Portishead Branch Line (MetroWest Phase 1)

Planning Inspectorate Reference: TR040011

9.3.3 ExA.SoCG-EA.D3.V2 - Statement of Common Ground

Date: December 2020

2.41 - Easton-in-Gordano Flood Mitigation Plan

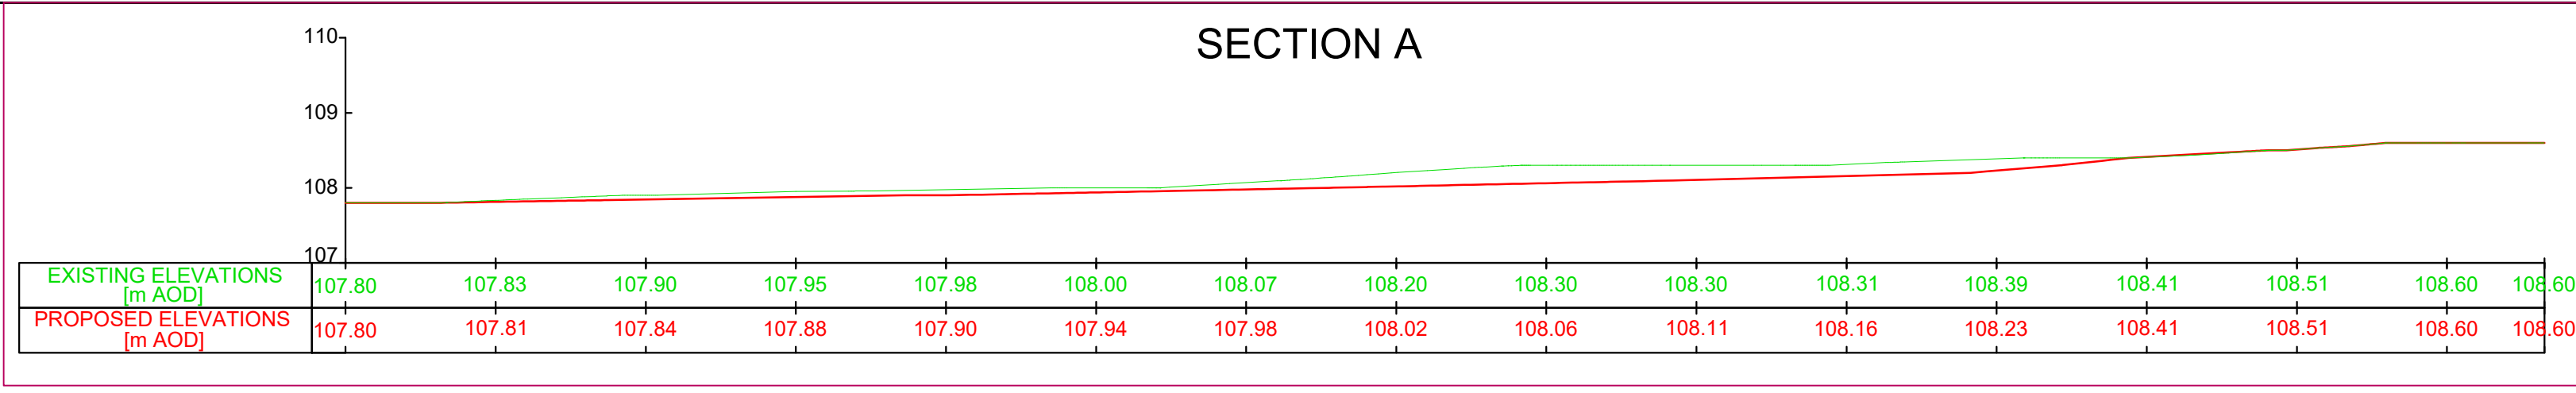
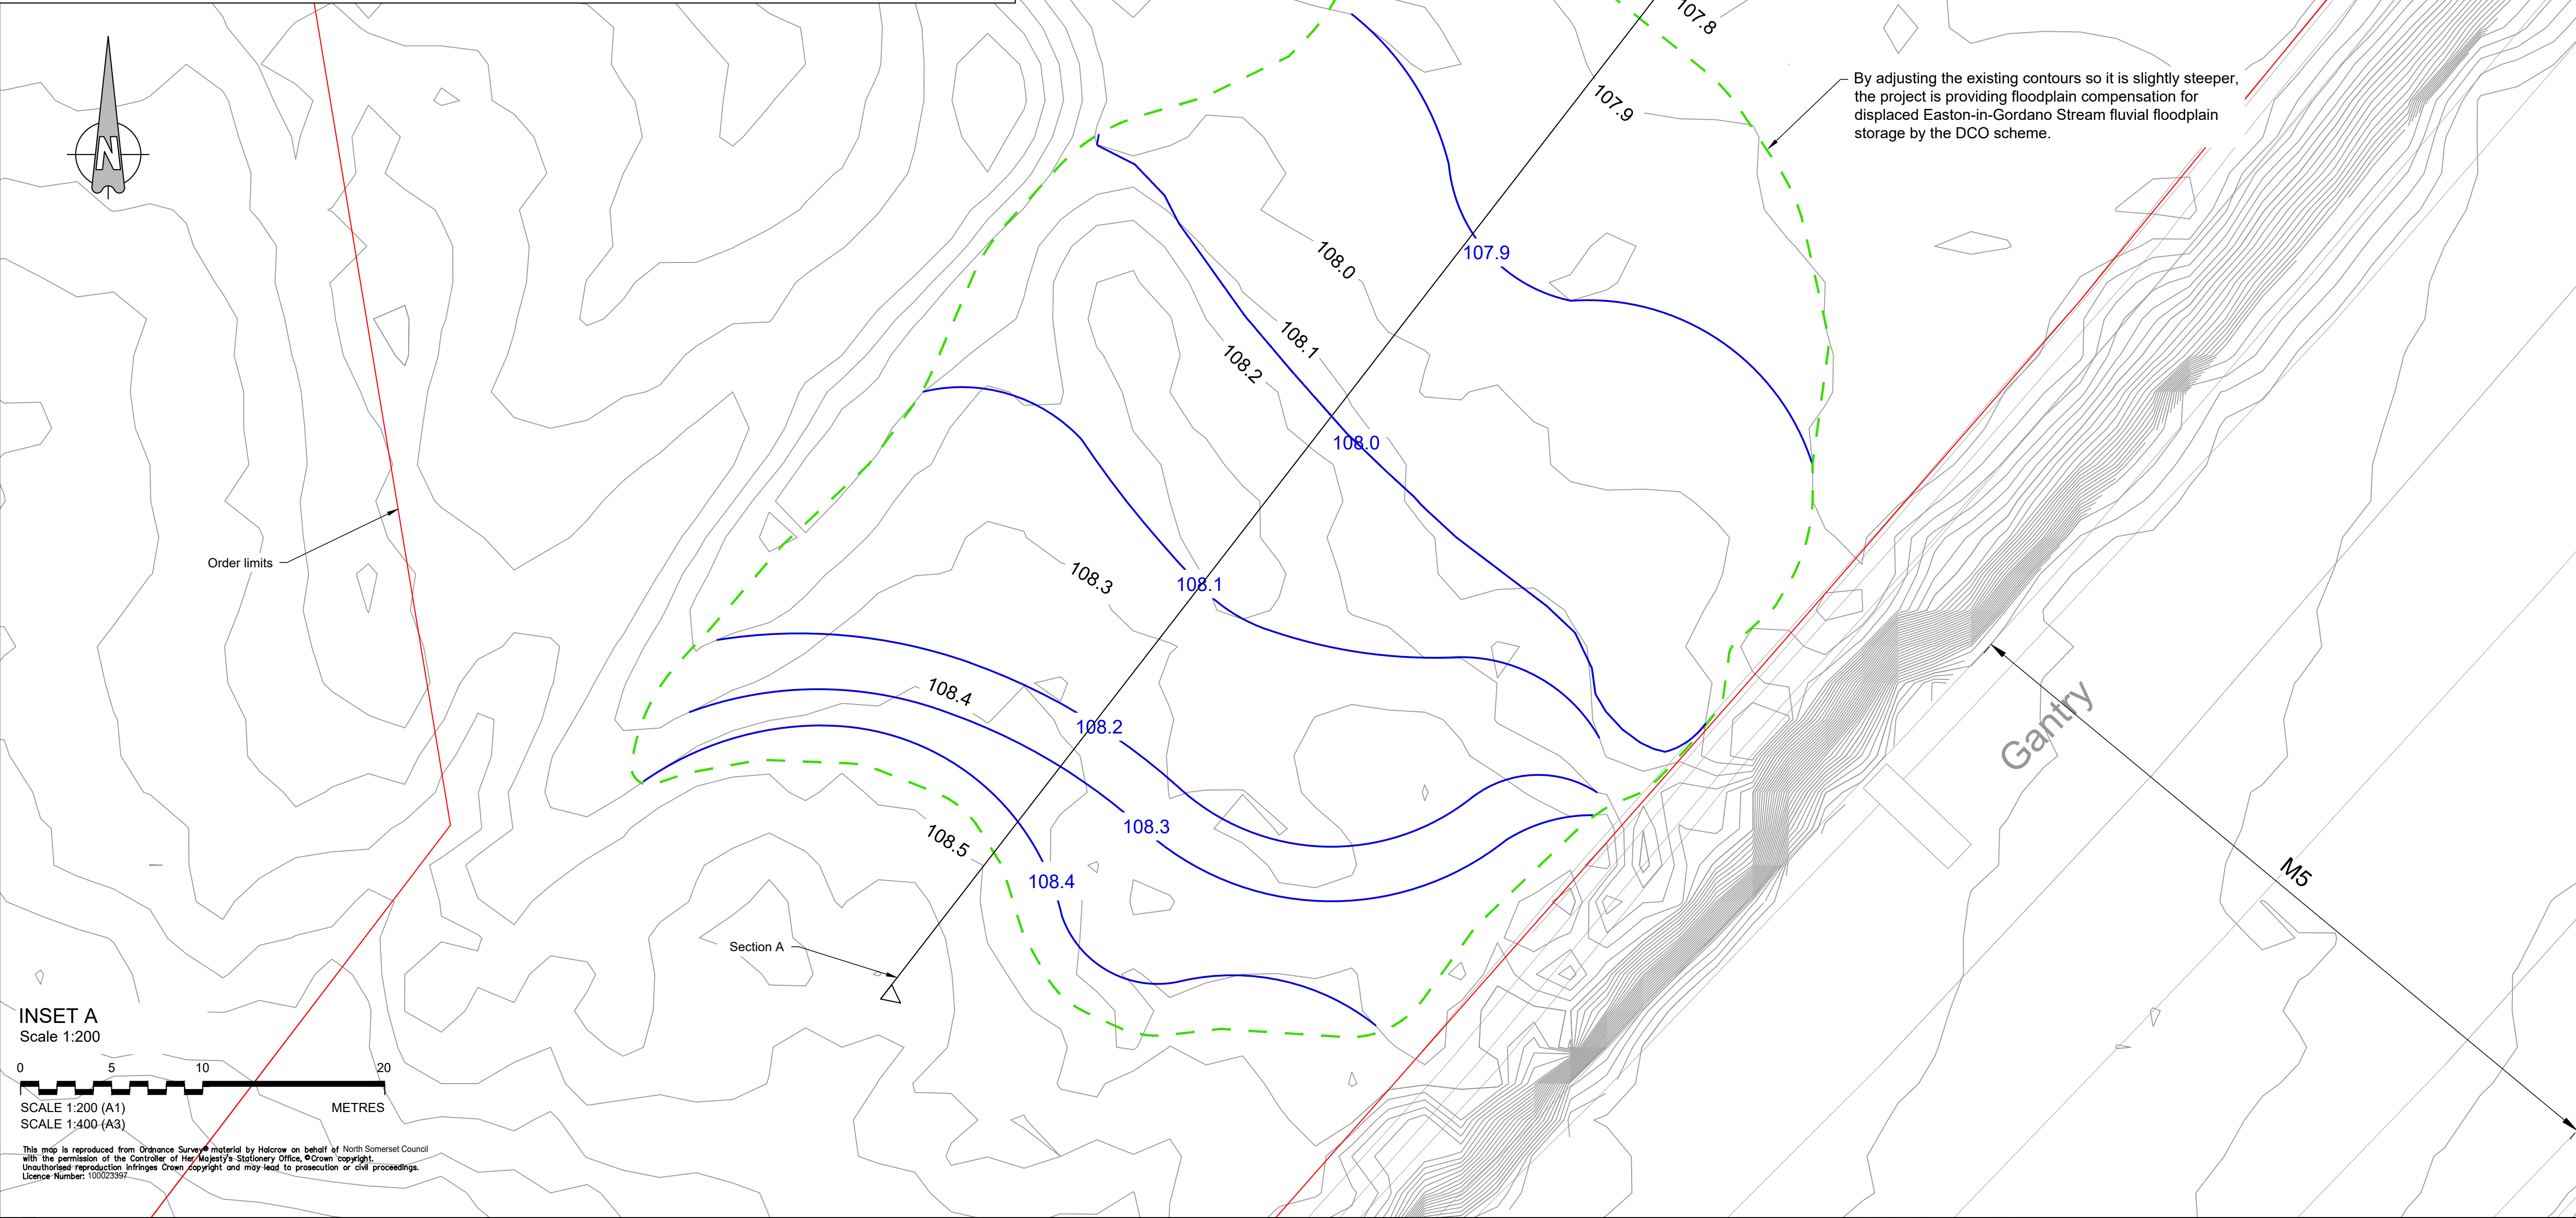
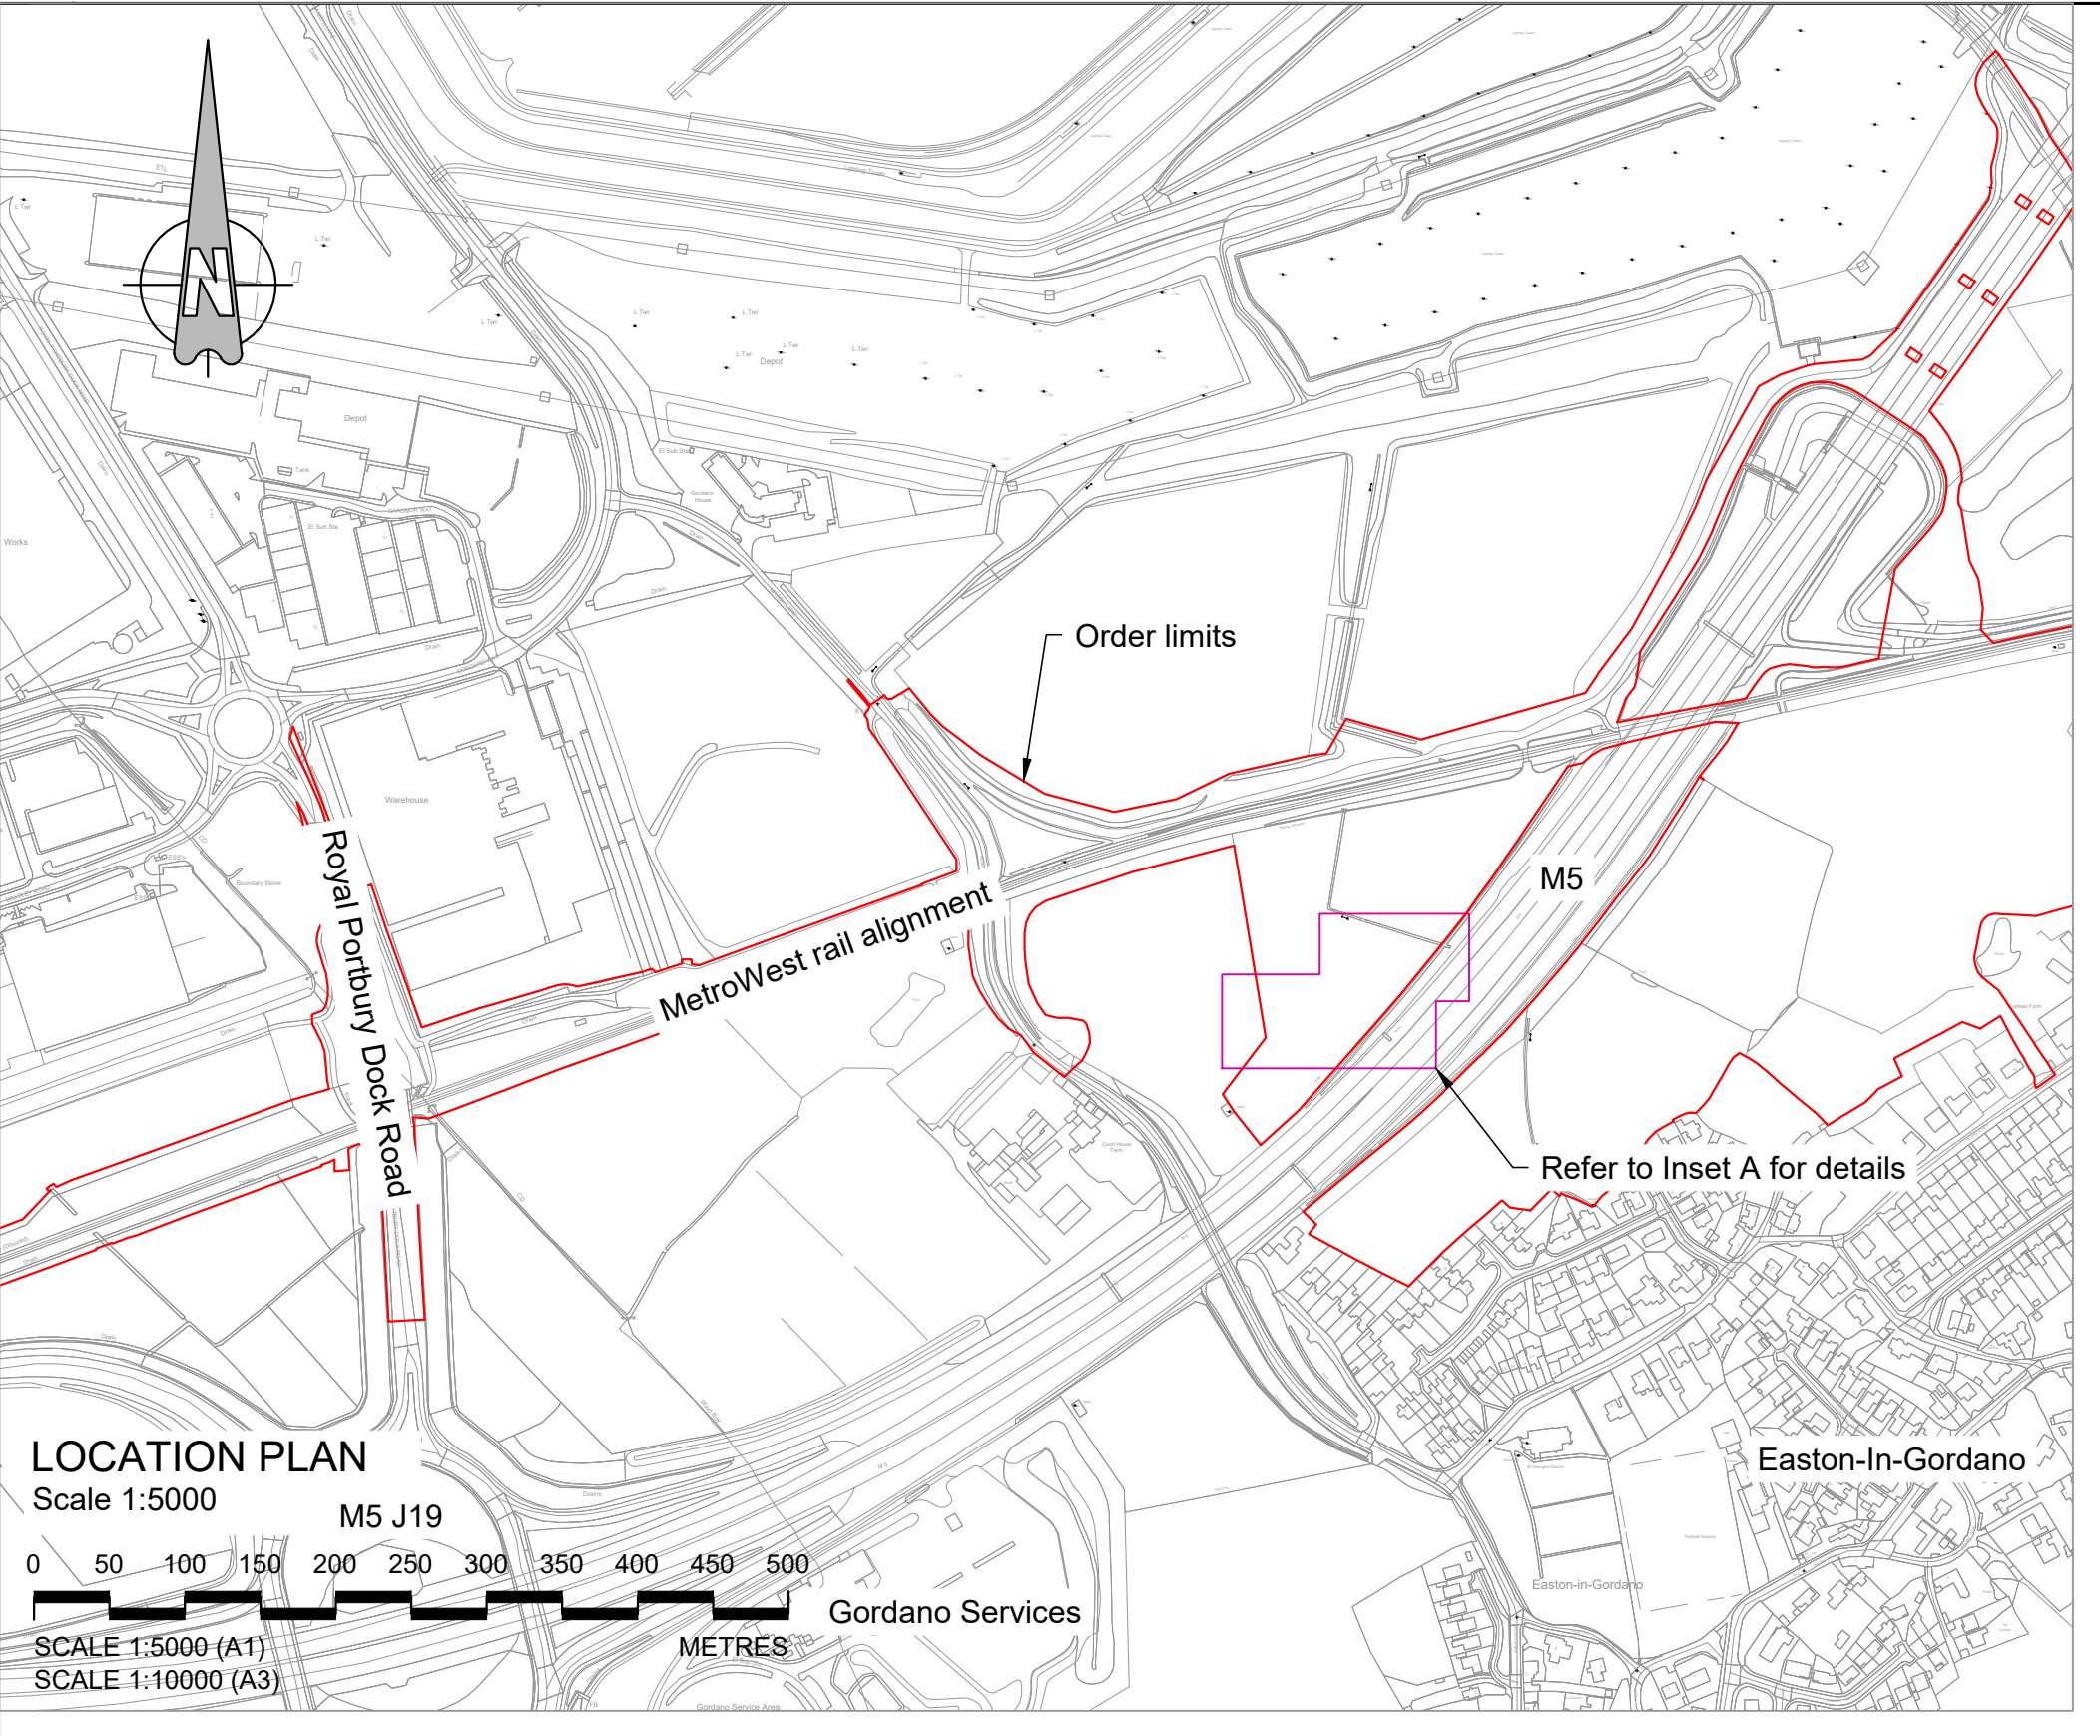
Ref	Topic	Environment Agency position	Applicant position	Status (Issue Resolved/Issue Outstanding)
		How many floodplain compensation areas are required for Easton in gordano
